No.	ELEMENT ADDRESSED IN COUNTY'S MAY 20, 2011 LETTER	<i>Summary of Impacts (From County 5/20/11 letter)</i>	Summary of Possible Mitigation	Applicant Response (Alternative Mitigation)	<i>County Initial Response¹</i>
1	Earth	<p><i>Earth - The proposed development includes areas of geological hazard that pose a threat to life and property. Portions of the site are subject to alluvial fan hazards that may result in sudden and destructive movements of water and water-bourn debris that is likely to result in loss of property and life in areas subject to this hazard. Portions of the site are subject to large magnitude water and debris flows across flatter portions of the site resulting from flows from steeper portions of the site as shown by large capacity dry channels that cross the westerly portion of the site. The easterly portion of the site is subject to rock-fall both in areas of existing talus slopes and from disturbance of the site from road, infrastructure and residential construction. These existing conditions along with the proposed development present the potential for significant adverse environmental impacts.</i></p>	<p>no development in alluvial fans or outflow areas; open

Figure 3-37 Marian Meadows. AIRPORT ELEVATIONS

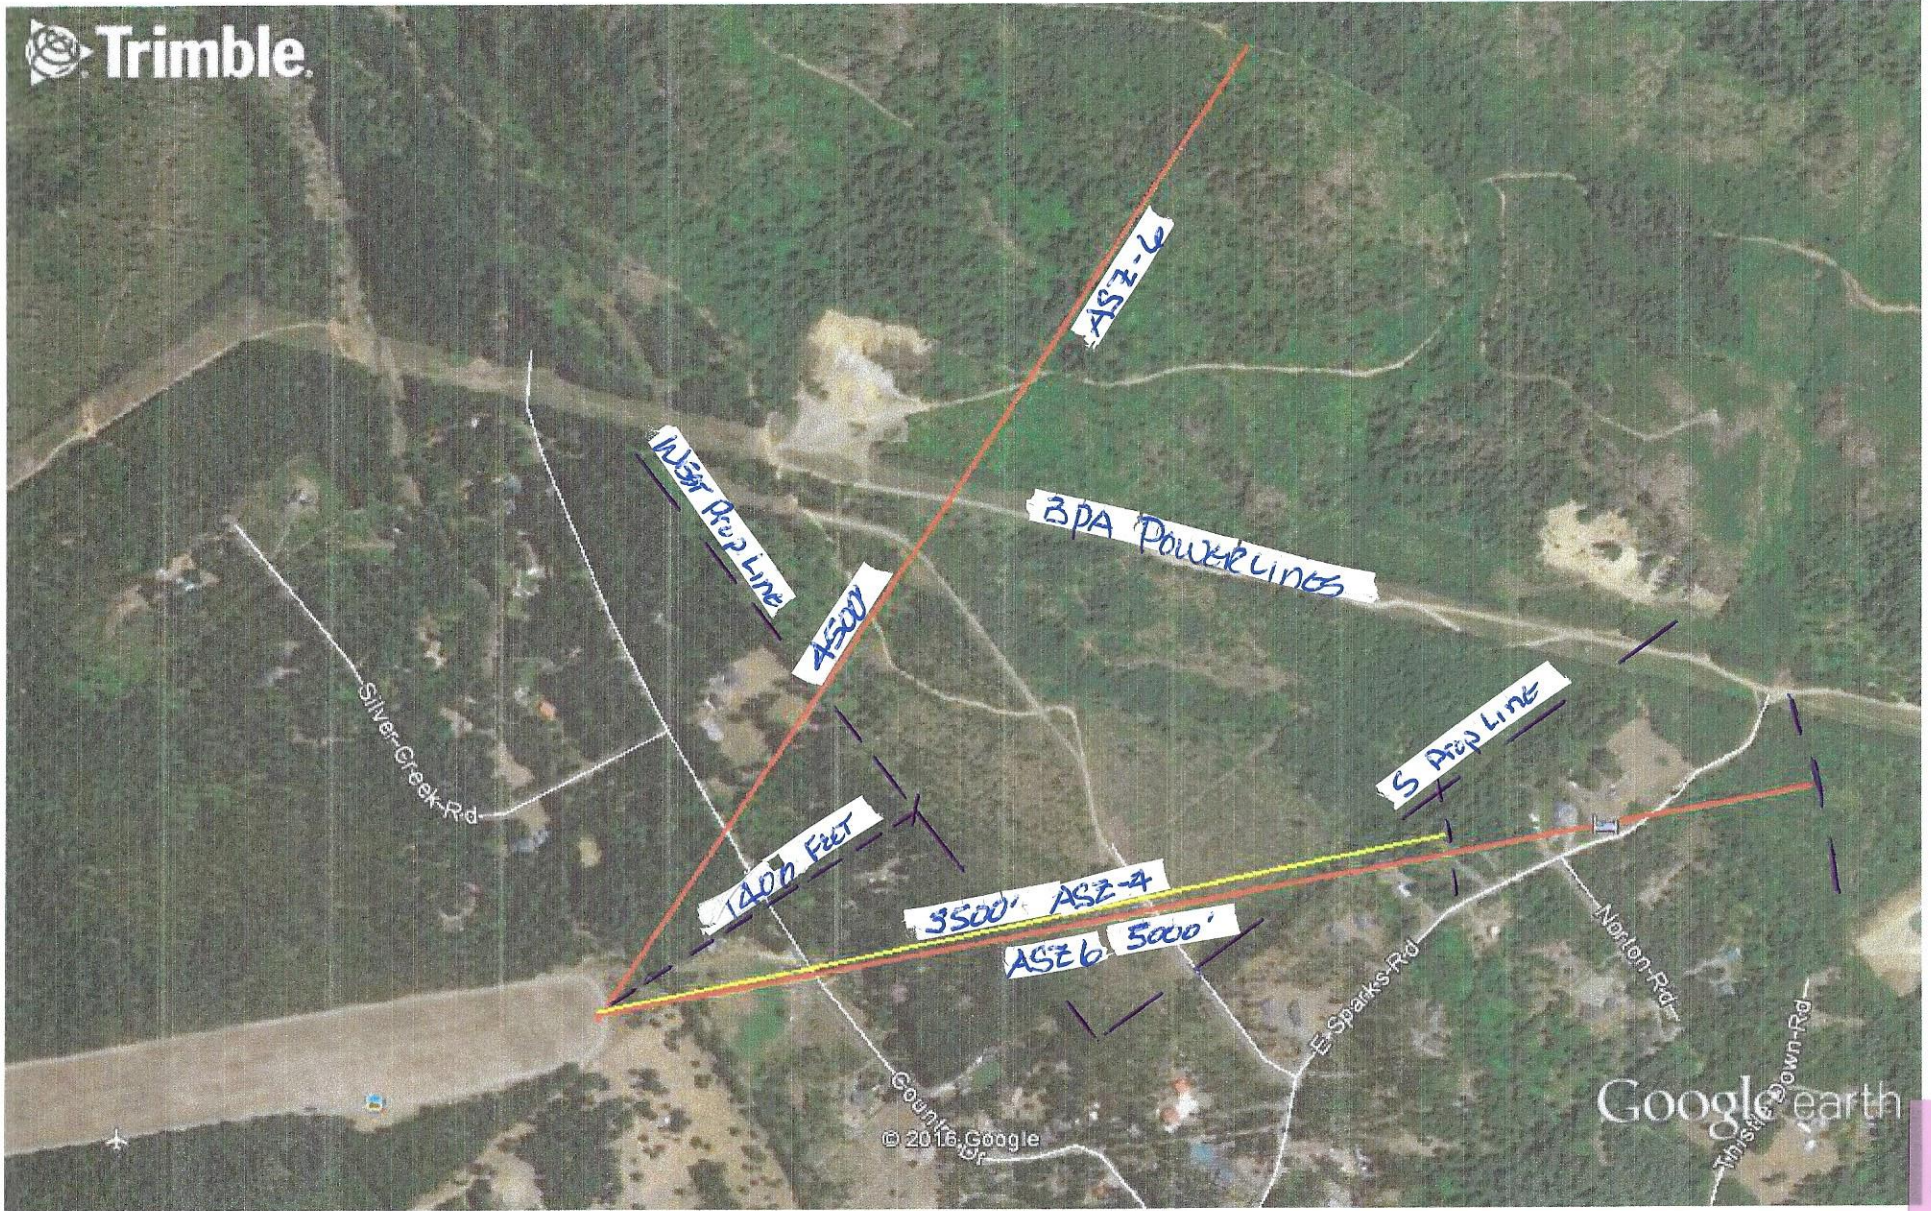
14B	Aviation	<p><i>14.3 Aviation – The proposed PUD is within Airport Safety Zones (ASZs) 3, 4 and 6 of the Easton State Airport. The area within ASZ 4 in alignment with the runway represents the greatest threat to potential future residents</i></p>	no development in ASZ 3 or 4; density limited to 1 unit per three gross acres in any ASZ	<p>The 2016 proposed development addresses airport operations in the following ways; - ASZ-4. any and all development within ASZ 4 will be limited to Storage facilities and community support structures like community recycling with restrictions on overnight use.</p>	<p>i) <i>In order to minimize hazards to life and property from airport operations, any subdivision or other development within the PUD site shall prohibit residential development within ASZ 3 and 4. Other</i></p>

No.	ELEMENT ADDRESSED IN COUNTY'S MAY 20, 2011 LETTER	<i>Summary of Impacts (From County 5/20/11 letter)</i>	Summary of Possible Mitigation	Applicant Response (Alternative Mitigation)	<i>County Initial Response¹</i>
		<p><i>located within the area from aircraft operation. Because of altitude and heat effects known as "high and hot," in which air density reduces the amount of lift generated by the wings of an airplane or the rotors of a helicopter, greater hazard is present along the alignment of the runway, including ASZ 4 and the area extending beyond ASZ 4.</i></p> <p><i>The proposed PUD exceeds both Kittitas County and WSDOT recommended densities in ASZs with 72 lots in the highest hazard ASZs 3 and 4.</i></p> <p><i>Accommodating the allowed density under Kittitas County Zoning of one unit per three acres within the ASZs increases risk as compared to the WSDOT recommendation of one unit per 5 acres. However, reduction in density in the ASZs to the WSDOT recommendation while providing the same overall density within the PUD increases the amount of development in more steeply sloping portions of the site outside of ASZs with greater potential geologic hazards and wildfire hazard.</i></p> <p><i>Avoidance of all development in ASZ 4 reduces hazard exposure in the area of highest risk along the alignment of the runway. Lots partially within ASZ 3 can be configured to eliminate building sites within the ASZ. These provisions, together with maximum density within ASZ 6 of one unit per 3 acres provides an acceptable balance between aviation safety impacts and impacts on geologic hazards and wildfire hazards of</i></p>		<p><u>-ASZ 6</u> – That region extending beyond ASZ 4 and subject to aircraft over flight will be restricted to RV and campsite usage with limited stay potential.</p> <p><u>-ASZ 3 & 6-</u> Those areas located north of ASZ 4 will contain all of residential development use. Under RCW 14.12.090 (1) expectation would be for aircraft to turn away from the 2000' elevation rise east of the Plat of Marian Meadows. This would be especially true for aircraft in distress. All residential construction will be confined to north of ASZ 4, and restricted from areas under the flight path beyond ASZ 4.</p> <p><u>Height Restrictions</u> – Plat restrictions will be in place limiting structure to 35' or under. (See Airport Exh.)</p>	<p><i>compatible development such as mini-storage may be located in those ASZs and lots may include those ASZs, as long as residential use is excluded.</i></p> <p>ii) <i>In order to minimize hazards from life and property from airport operations, the maximum density within all portions of the site encumbered by ASZs shall be no more than an average density of one unit per three gross acres.</i></p>
